I am writing as a parent of a child that attends Darlington Public School regarding the proposed development by the University of Sydney, MP 07_0158 – Abercrombie Street Precinct, Syd Uni. Darlington Public School is an inner city school servicing the suburbs of Chippendale, Darlington and parts of Redfern. The school is directly adjacent to the western border of the project.

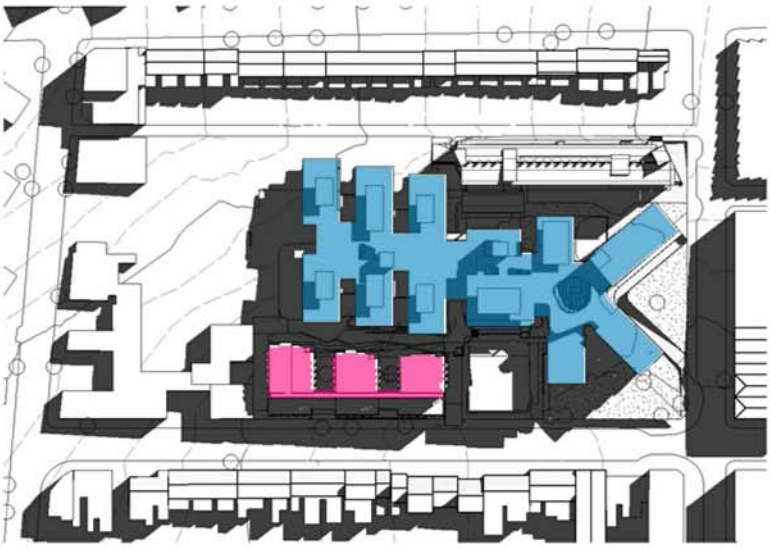
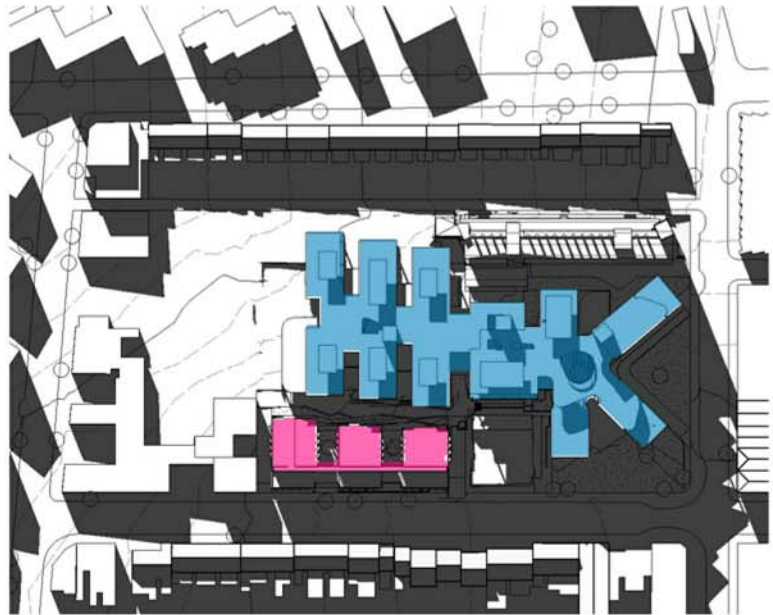
The new Business facility building will be seven stories high, and with its location in the North West corner of the school playground it will cause a large shadow effect over the majority of the playground.

What consideration has been given to this impact, and the requirement for natural light for the play areas, making it a suitable area to play?

Figure 36: Construction Vehicle Access Routes

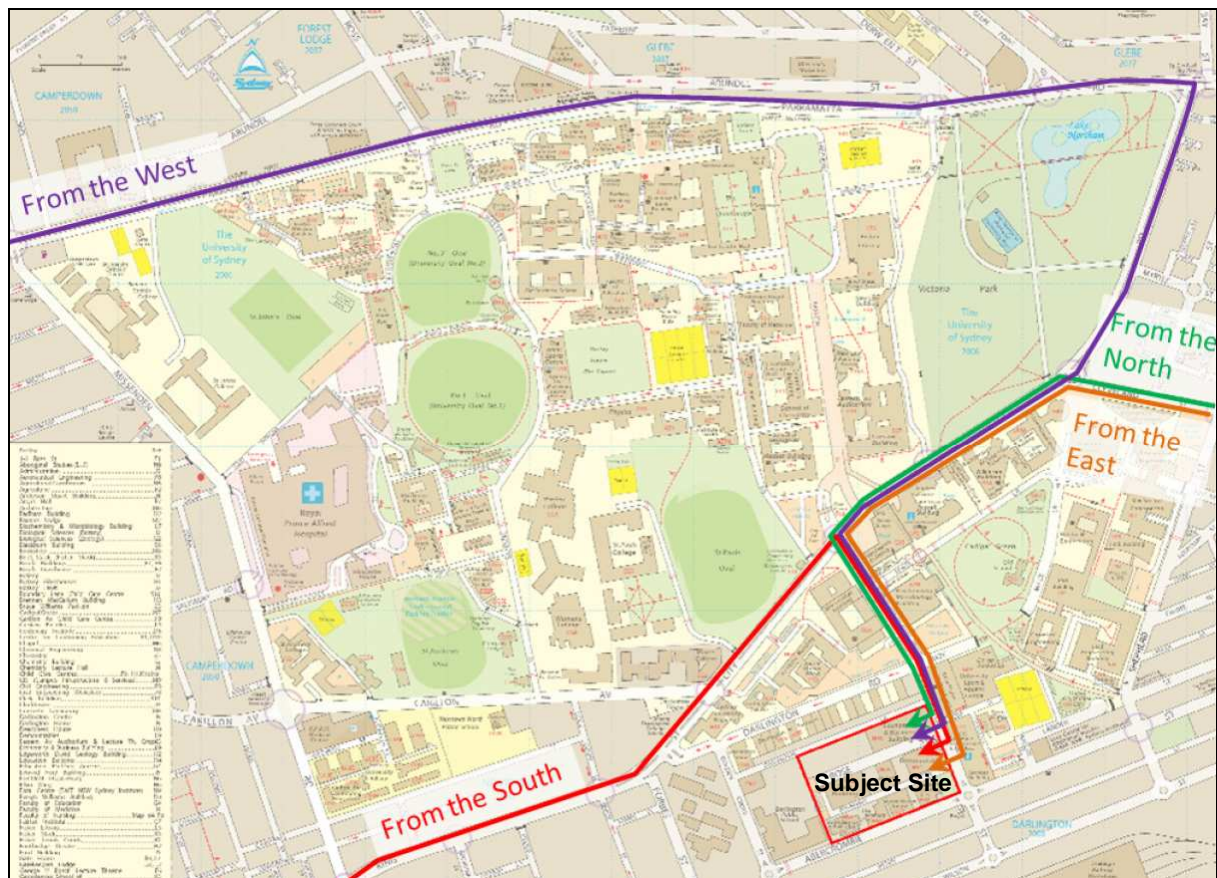
The proposed access point for the site is on Abercrombie Street and is directly adjacent to the school classrooms on their North East border of the school site. Locating the access point for trucks would:

It needs to be stressed that the University of Sydney properties are the only properties that would be impacted by the entry point being in Codrington Street or Darlington Lane. Proposing an entry point in Abercrombie Street will force trucks and plant to be transported through residential and school areas to the project site. The more direct route is from City Road to Codrington Street and will allow access directly into the project site without passing through residential areas or the proposed access that is within metres of classrooms, or across the footpaths and pedestrian crossing that children use to access the school.

The Transport Impact Assessment notes that the only rationale for not using Codrington Street is that it is a 'pedestrian spine'², which is incorrect as during the construction activity the whole site will be in very limited use by the University's 'pedestrians'. In addition, these pedestrians, predominantly adults, are better able to navigate driveways and construction zones, presenting a lower safety concern.
